**From:** Jo Gaul <admin@kidlington-pc.gov.uk>  
**Sent:** 21 December 2022 11:21  
**To:** Planning <Planning@Cherwell-DC.gov.uk>  
**Subject:** Planning Comments - URGENT HELP NEEDED  
**Importance:** High

22/00747/OUT Land at Bicester Road, Kidlington

The objections of Kidlington Parish Council to this application still pertain, additionally:

Access Strategy

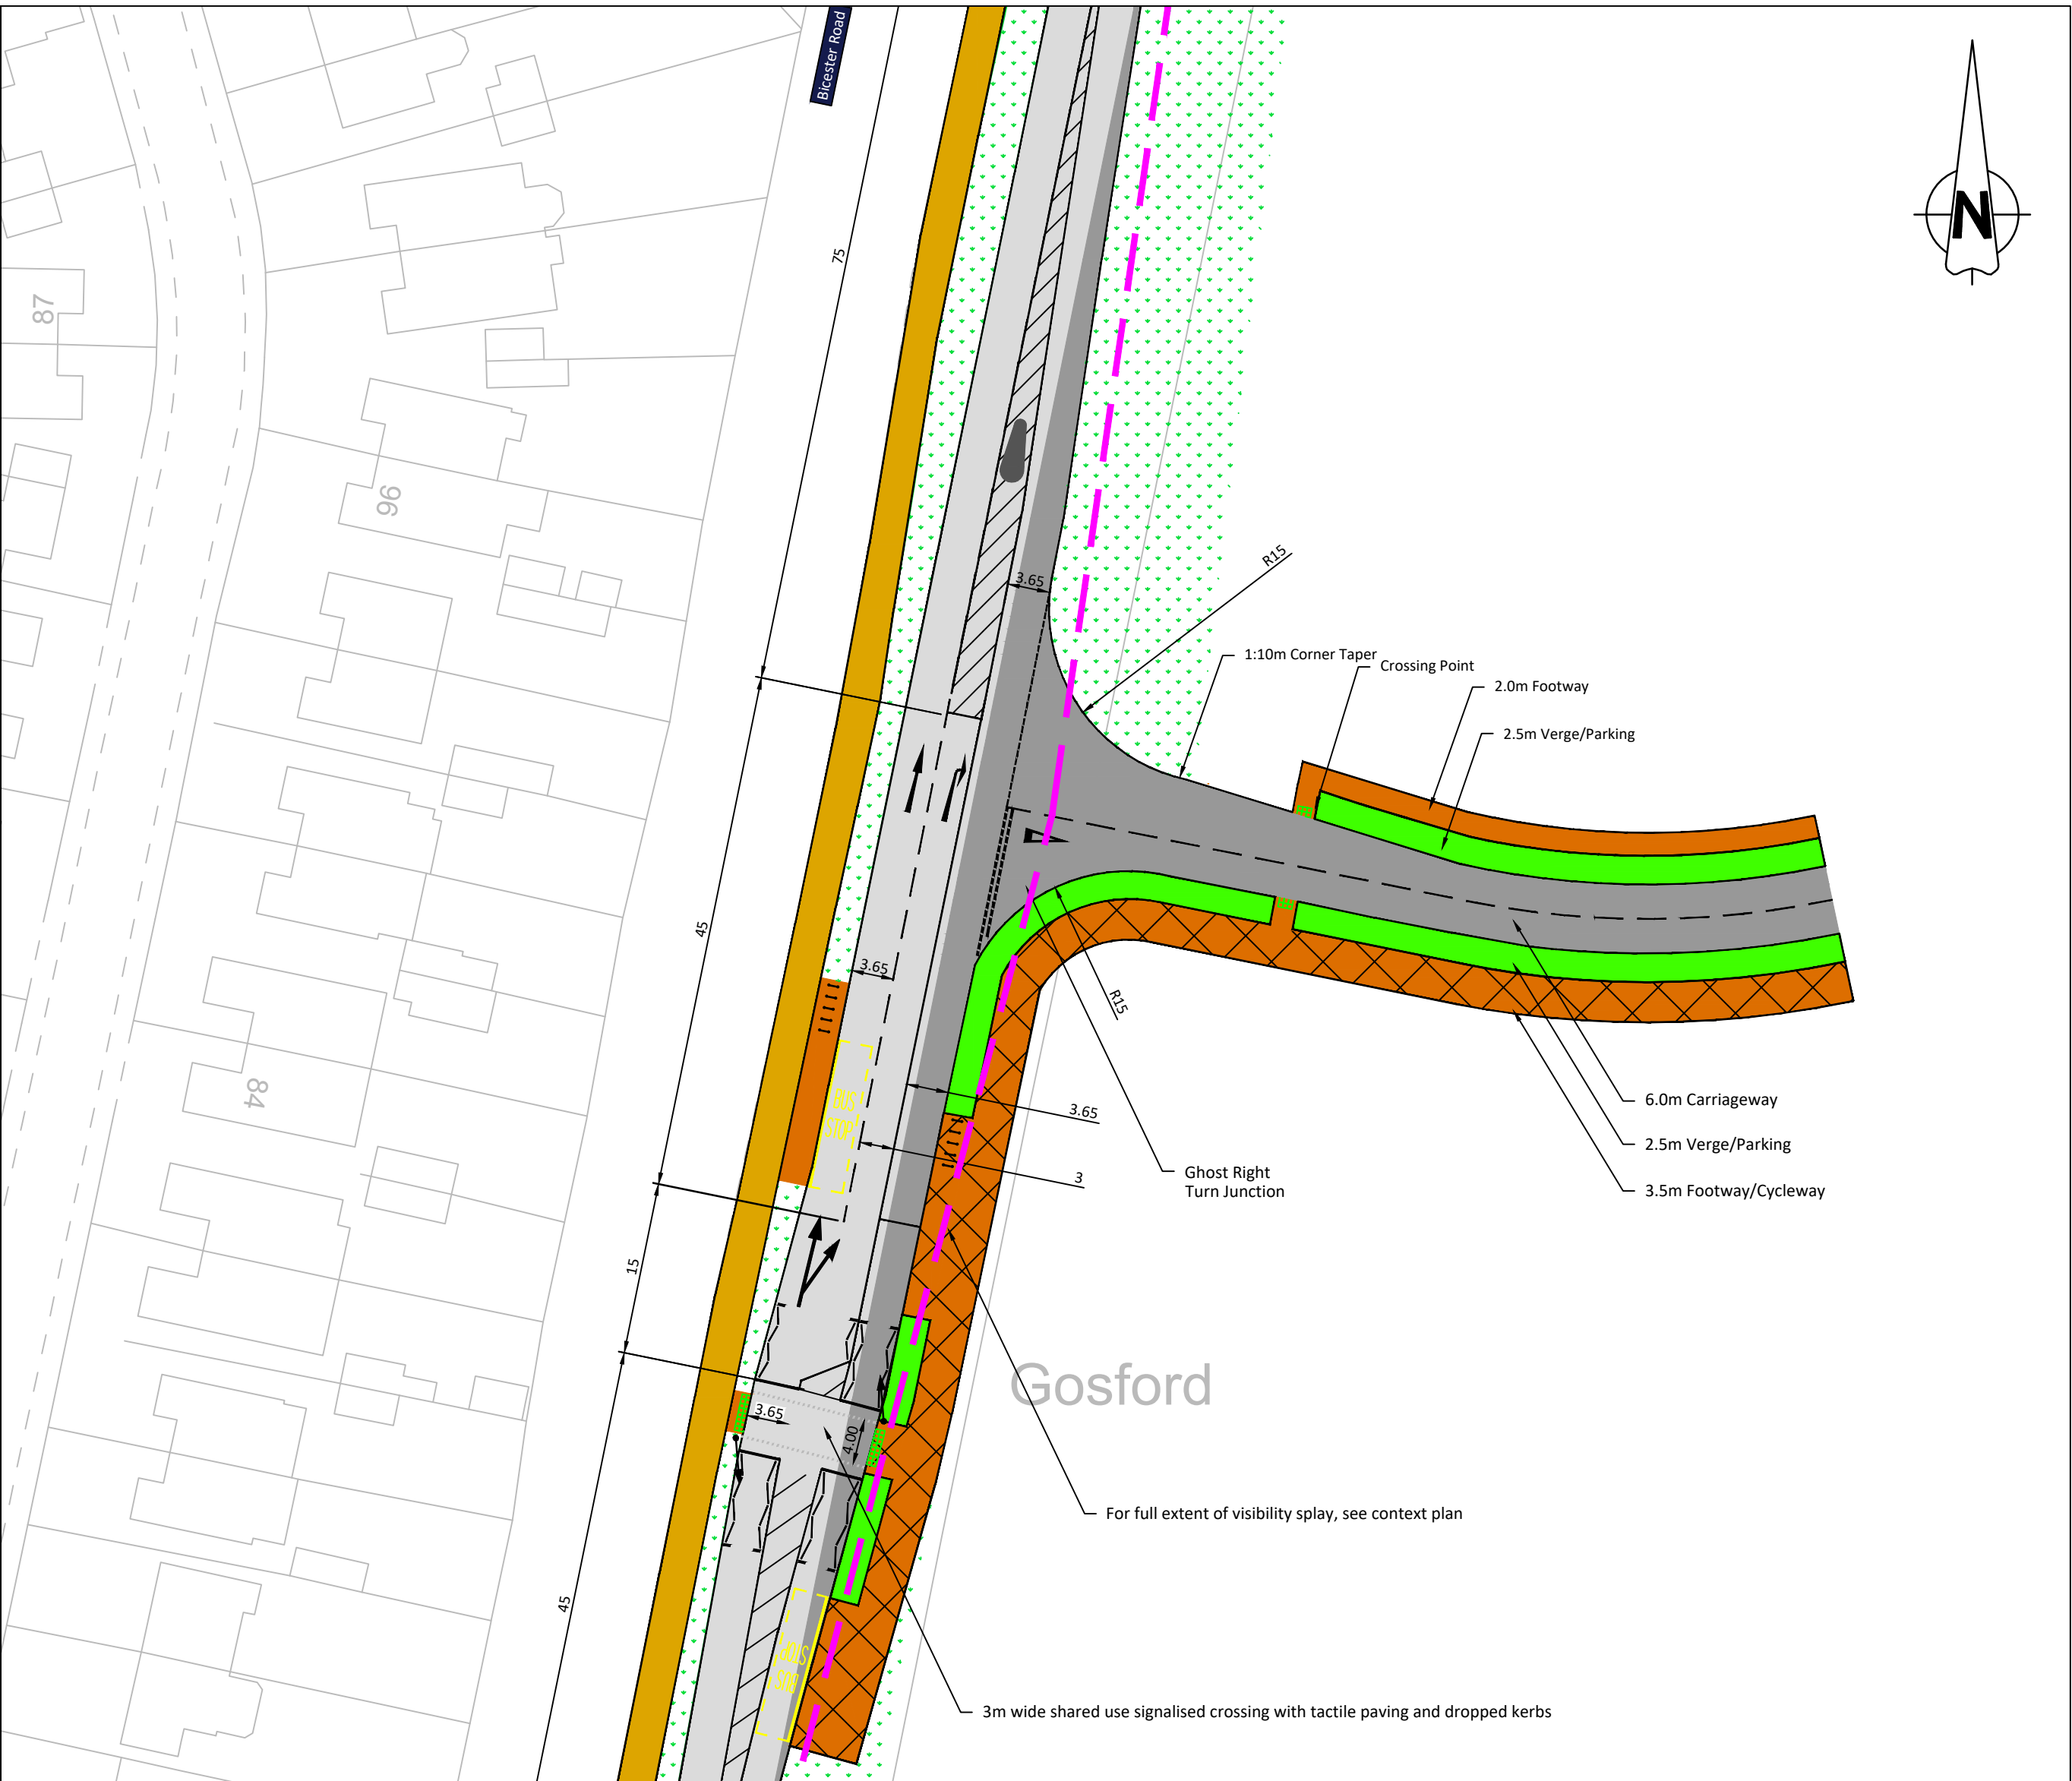
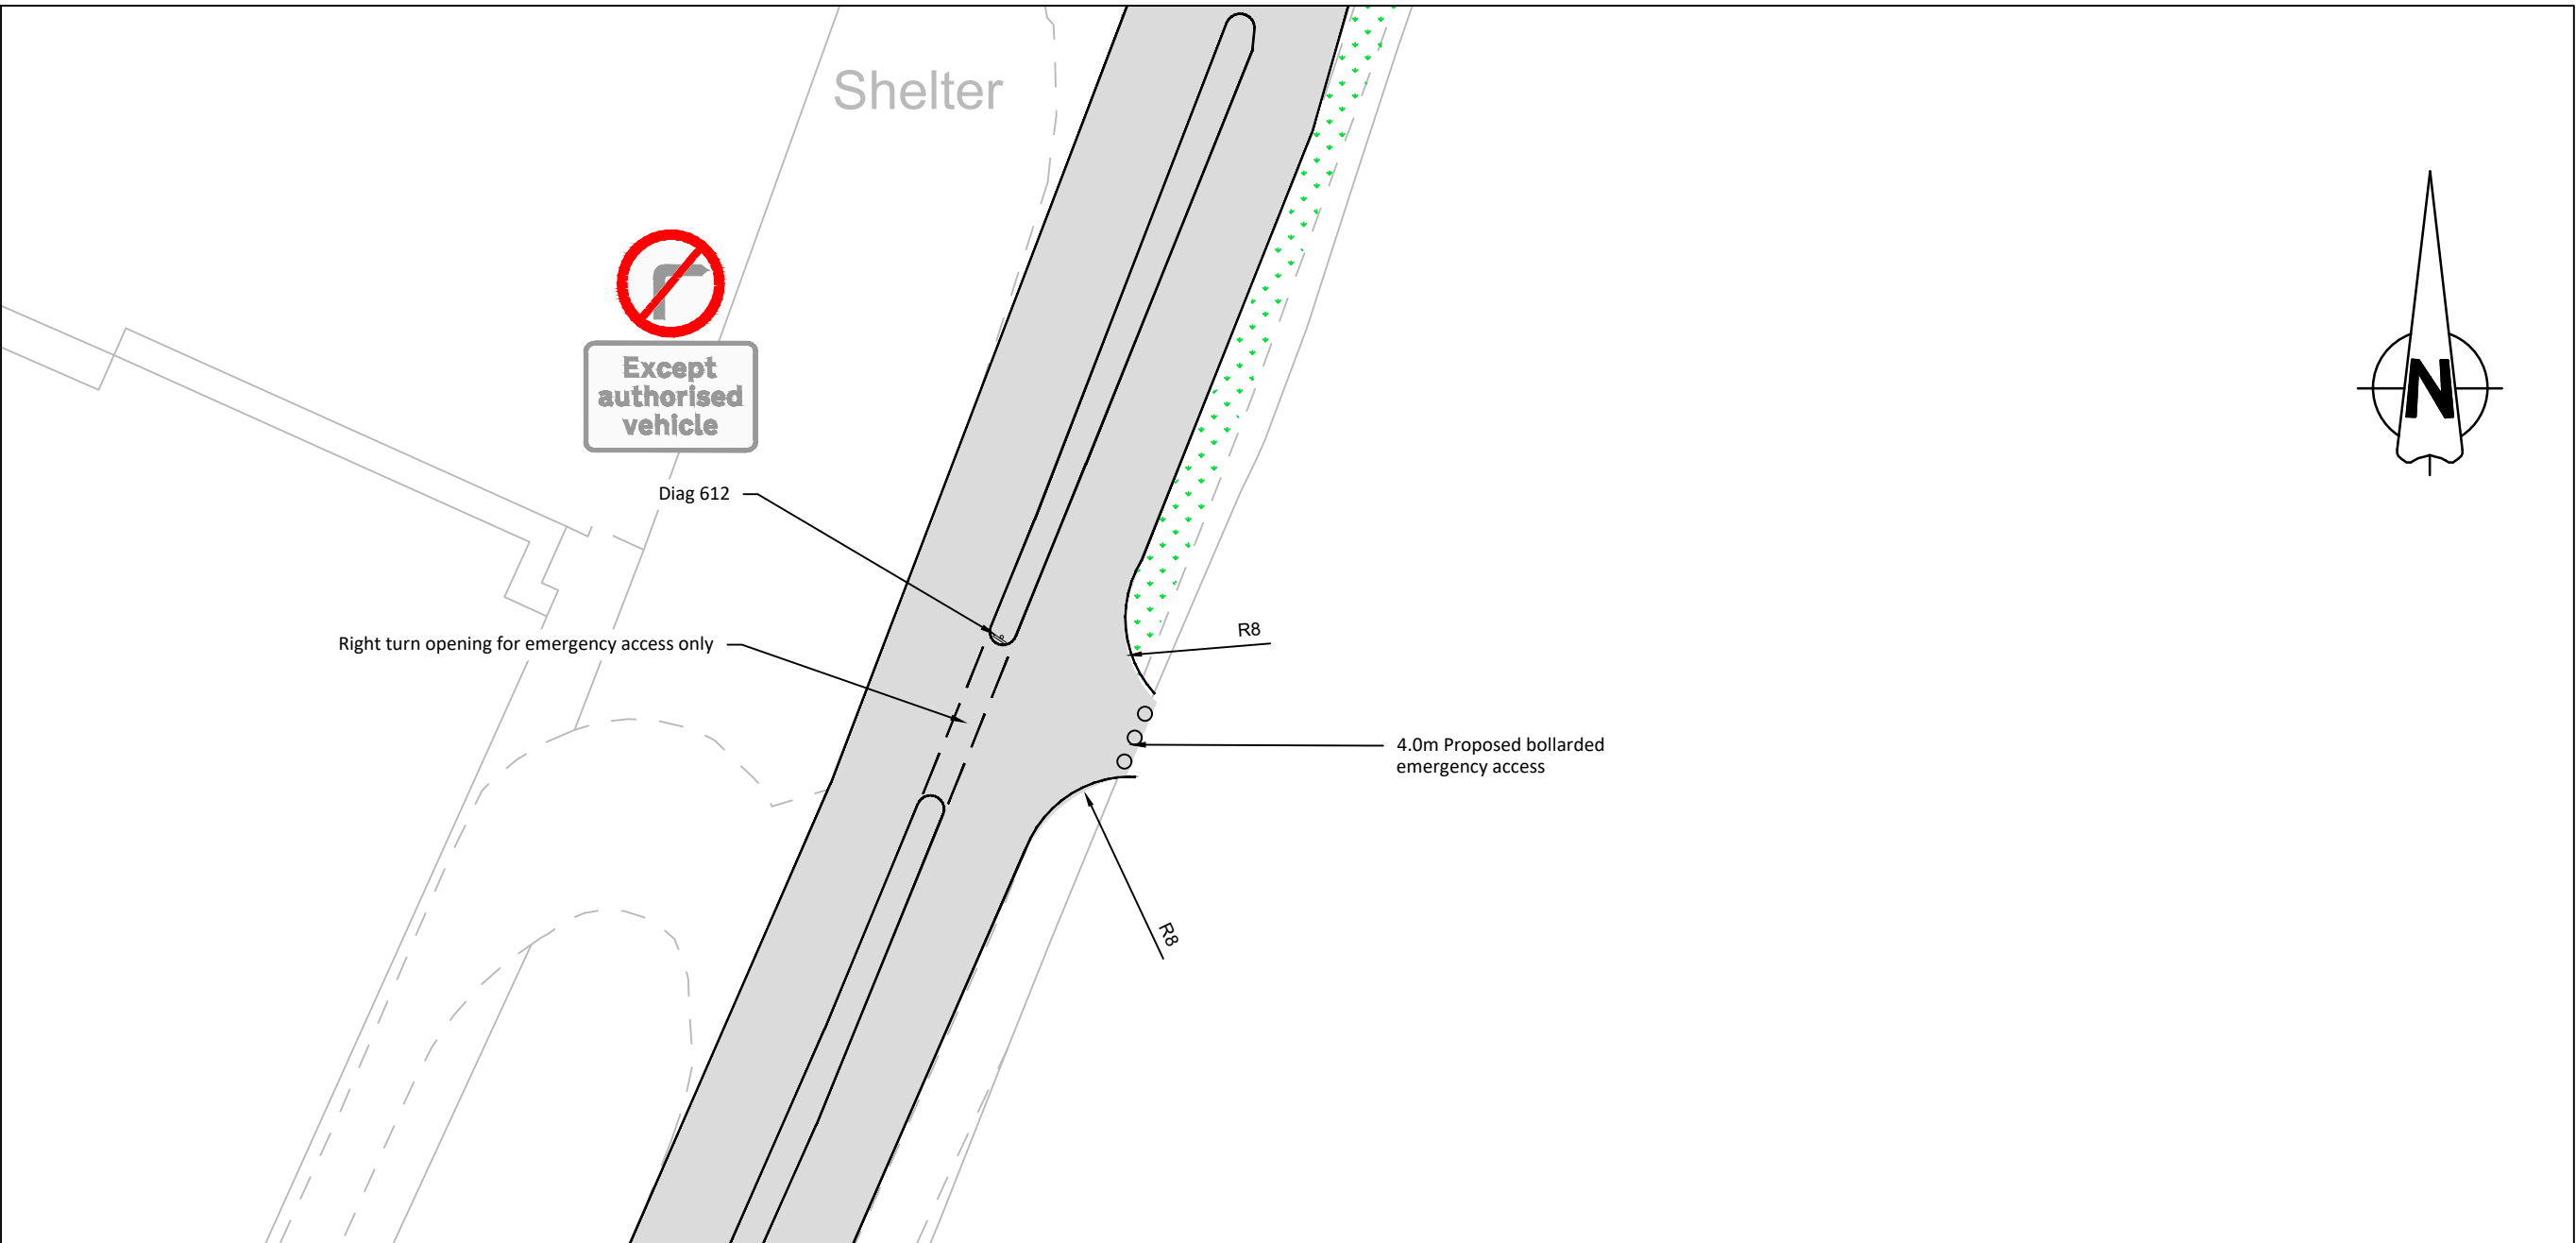
- 1, The application needs to demonstrate full vehicular access to the Gosford Link Road to avoid users of the community building, playing fields and allotments needing to use the vehicular access through the Hill land to the north.
2. The playing field provision is considered inadequate.
